20 July 2022

Our Ref: 16083_TP_RP_MOD5_AMEND

**RE: SECTION 4.55(1A) MODIFICATION TO MAJOR PROJECT APPROVAL 06_0143
THE GLADES ESTATE RESIDENTIAL SUBDIVISION – MOONEE BEACH
LOT 1 & 2 IN DP 725785**

Open Space Dedication

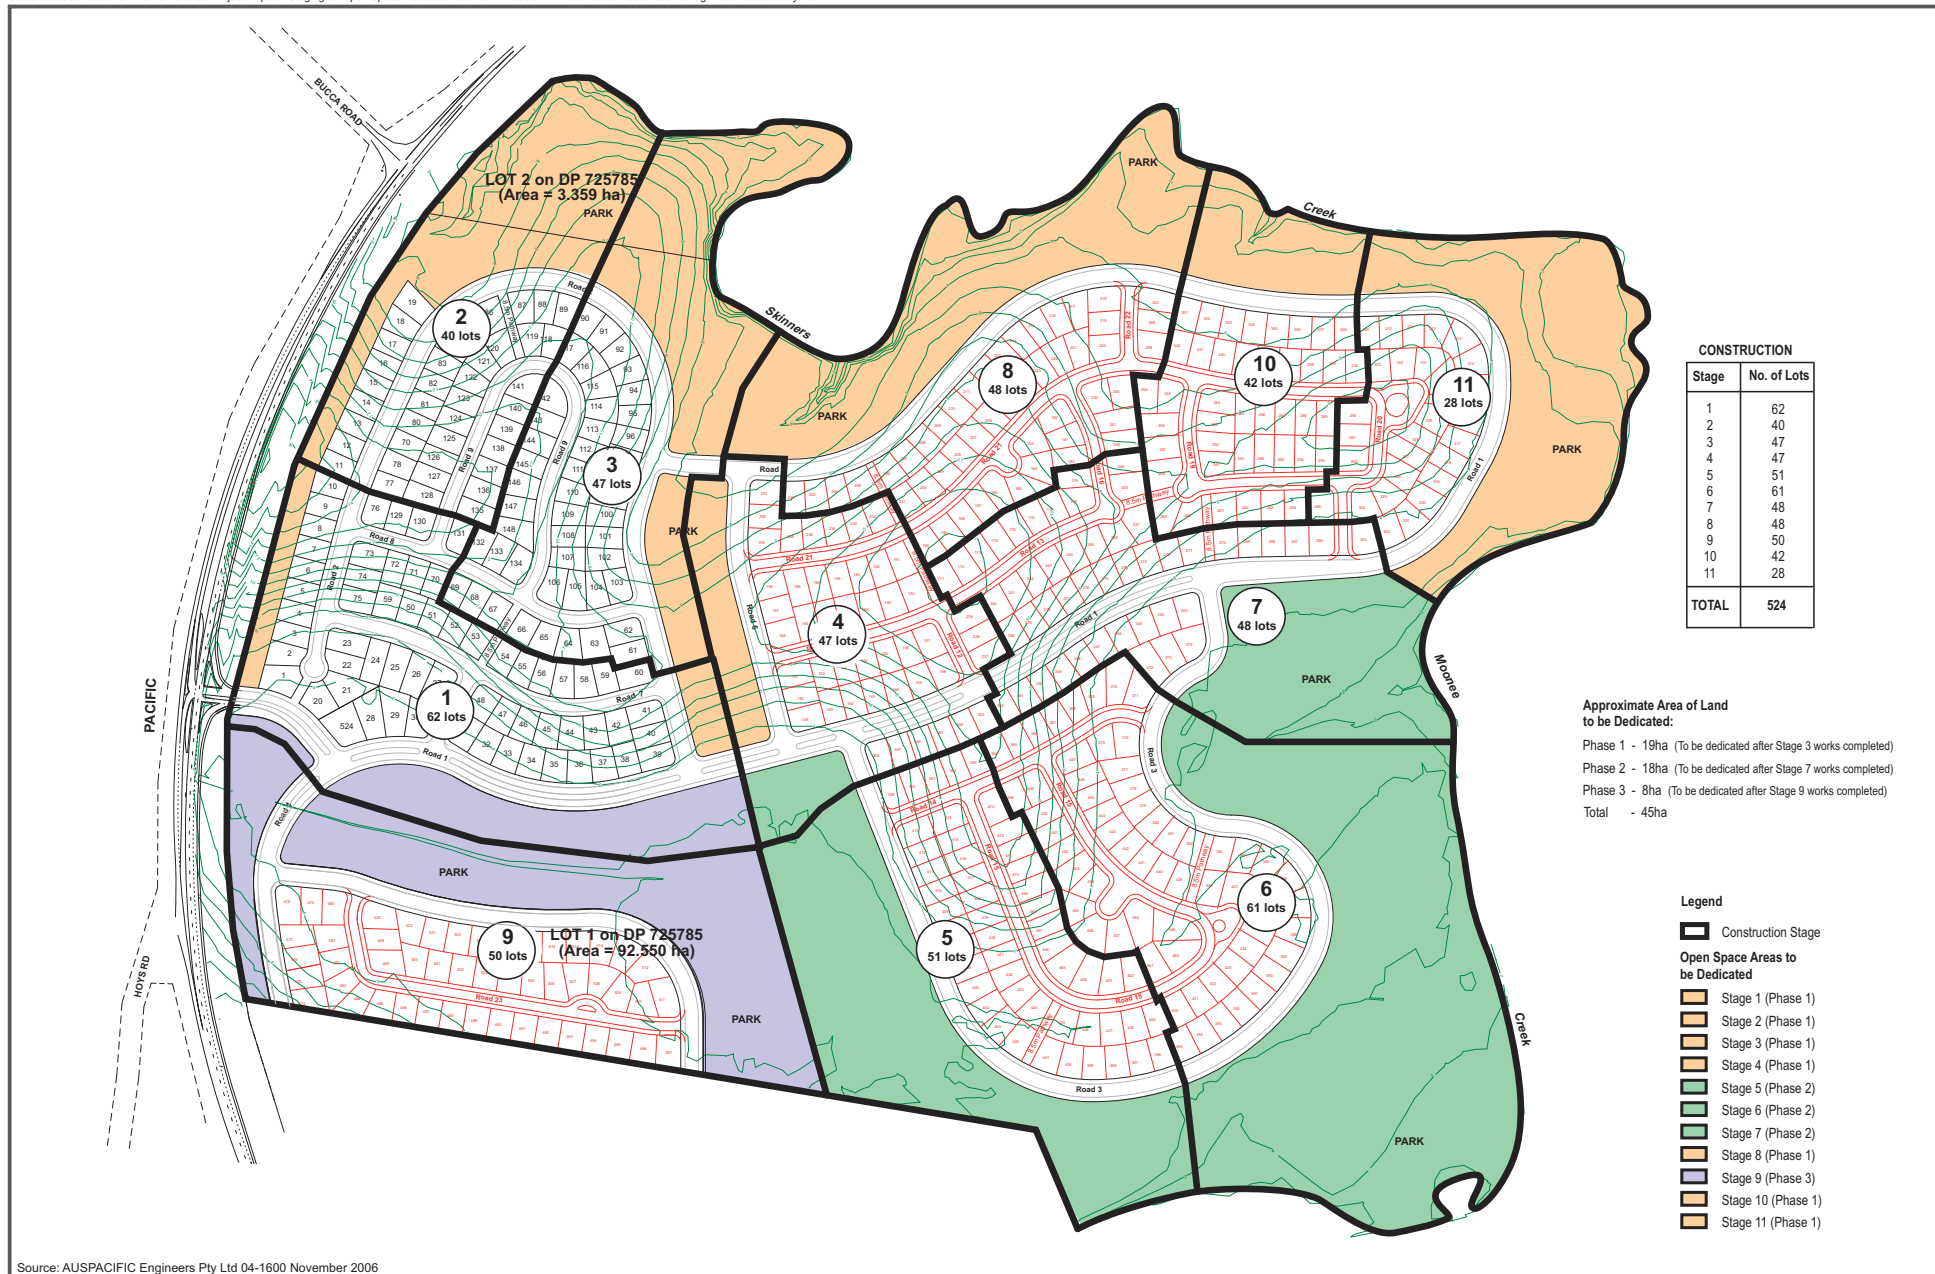
The dedication of this area is required in accordance with Condition E14, and in accordance with the sequence shown on the approved plan titled 'Staging of Open Space Dedication to Council December 2008', Annexure E. A copy of this plan is attached.

The currently approved phased dedication of open space / habitat conservation areas in accordance with Condition E14 is problematic for most construction stages. Under the current arrangement, construction activities associated with subdivision infrastructure provisioning would be required on land that has been embellished in accordance with an approved vegetation management plan and subsequently dedicated to Council as public open space before all the relevant infrastructure is satisfactorily completed and dedicated to Council.

This issue is evident for subdivision stages 4,8,10 & 11. At the completion of subdivision development stage 3, the open space / habitat conservation areas that adjoin these later subdivision development stages, being 4,8,10 & 11, are required to be dedicated to Council.

To counter this issue, we propose that the dedication of the relevant adjoining open space/habitat conservation land occur in accordance with the attached plan, titled 'Subdivision Staging and Staging of Open Space Dedication to Council' plan prepared by J. Wyndham Prince, dated 02/03/22. Regarding this plan, we note the proposed modifications to:

- a) the alignments which define the dedication of each open space area for Stages 1,3,4,5,8 & 9 and the accompanying table shown thereon, and
- b) the alignments that define the subdivision development staging so that they coincide with the proposed changes to the open space dedication to council for Stages 1,3,4,5,8 & 9.

Dedication to Council of Phase 1,2 & 3 Open Space Areas in accordance with the plan "Subdivision Staging and Staging of Open Space Dedication to Council' plan prepared by J. Wyndham Prince, dated 02/03/22.
